Letter of Intent Site Development Plan

Black Cherry Investments LLC
1453 Woolsey Hts
Colorado Springs, CO 80915
Project Name: Gearhead Garage Inc.

Legal: Lot 9 Claremont Business Park Fil No 1A
Address: 1453 Woolsey Hts
Colorado Springs, CO 80915
Lot Size: 0.65 Acres
Zoned – CS-CAD-O
Parcel Number: 54081-01-031

1 of 4
 SITE PLAN & DETAILS

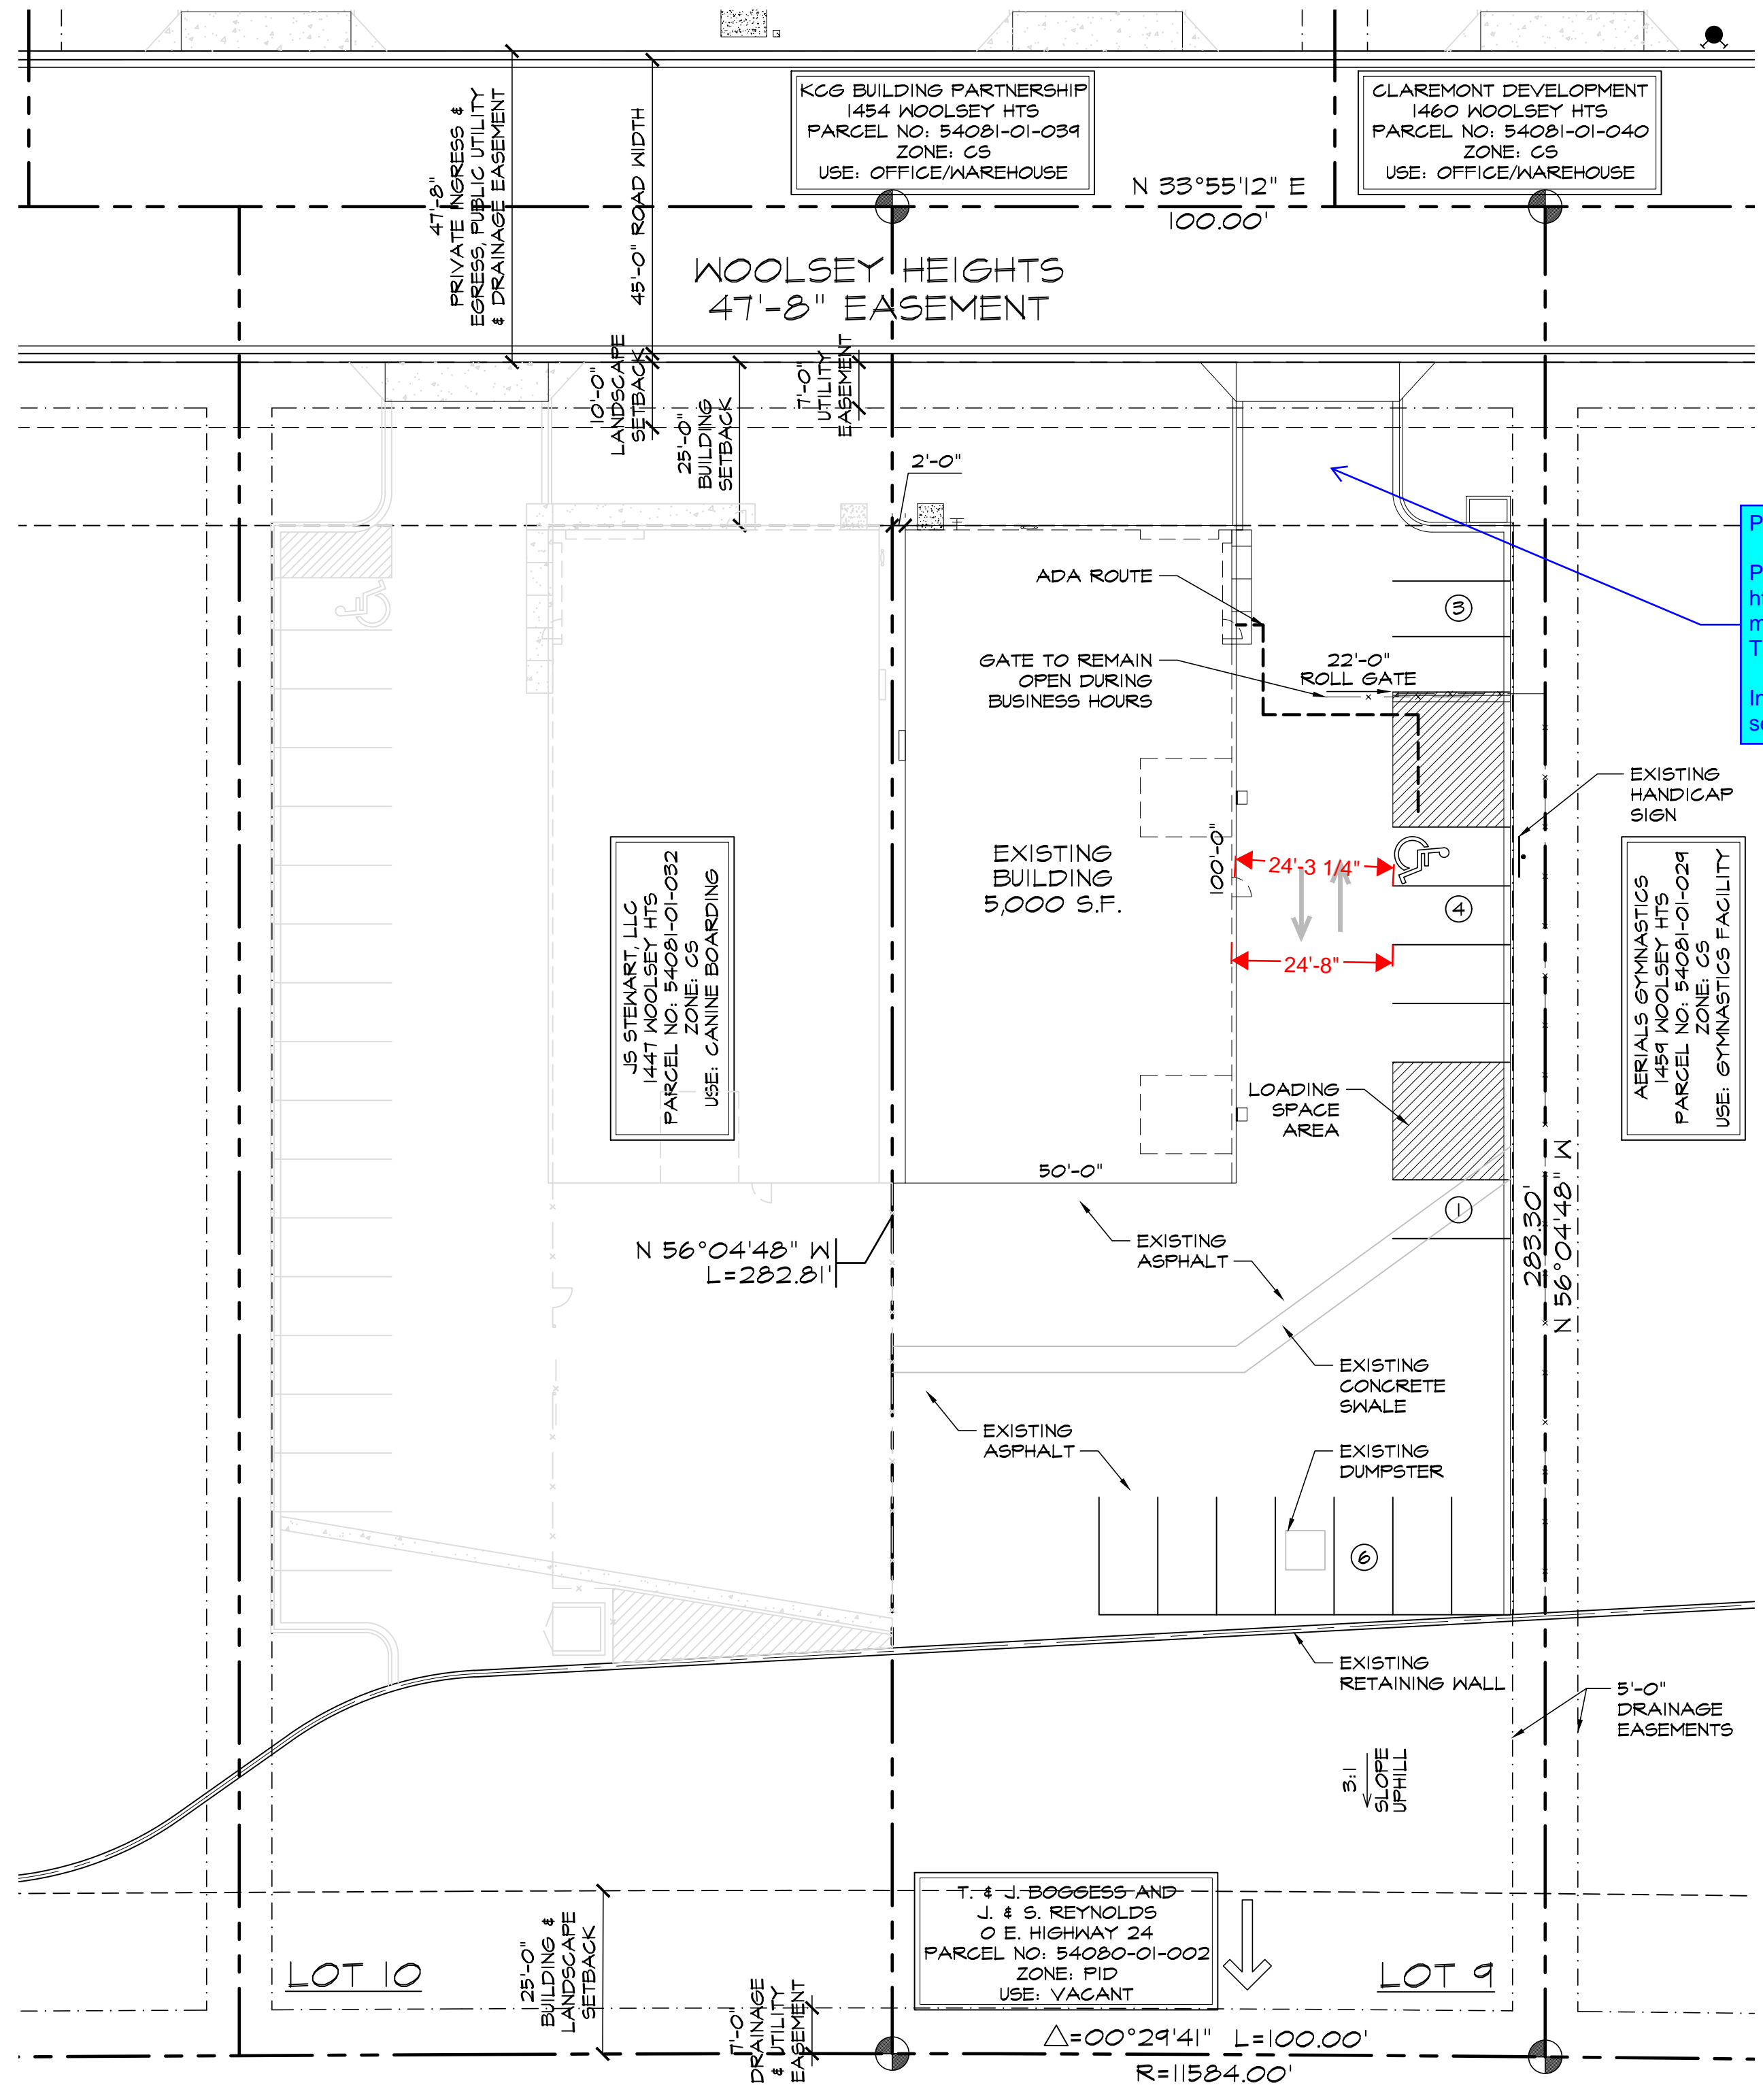
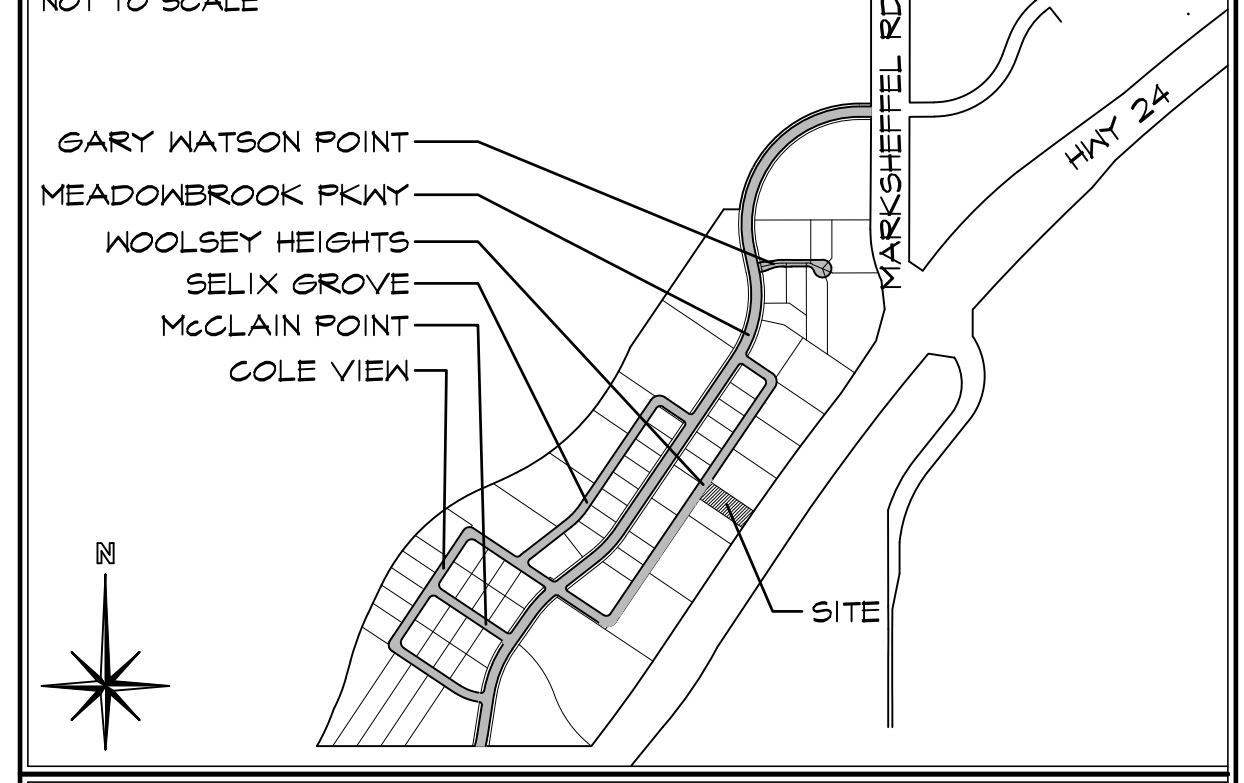
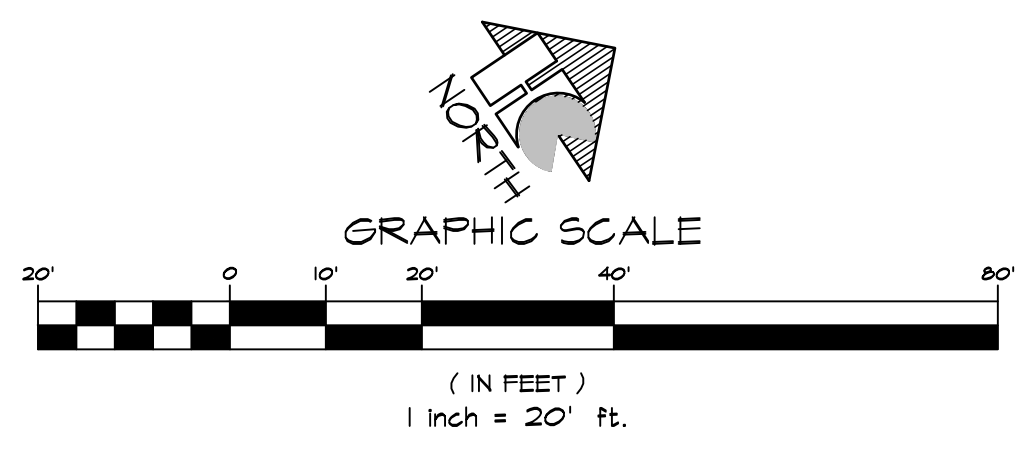
Applicant is required to apply for a driveway access waiver in accordance to plat note.

Please add "PCD File No. PPR-21-063".

This is an existing driveway which we previously applied and paid for.

Added
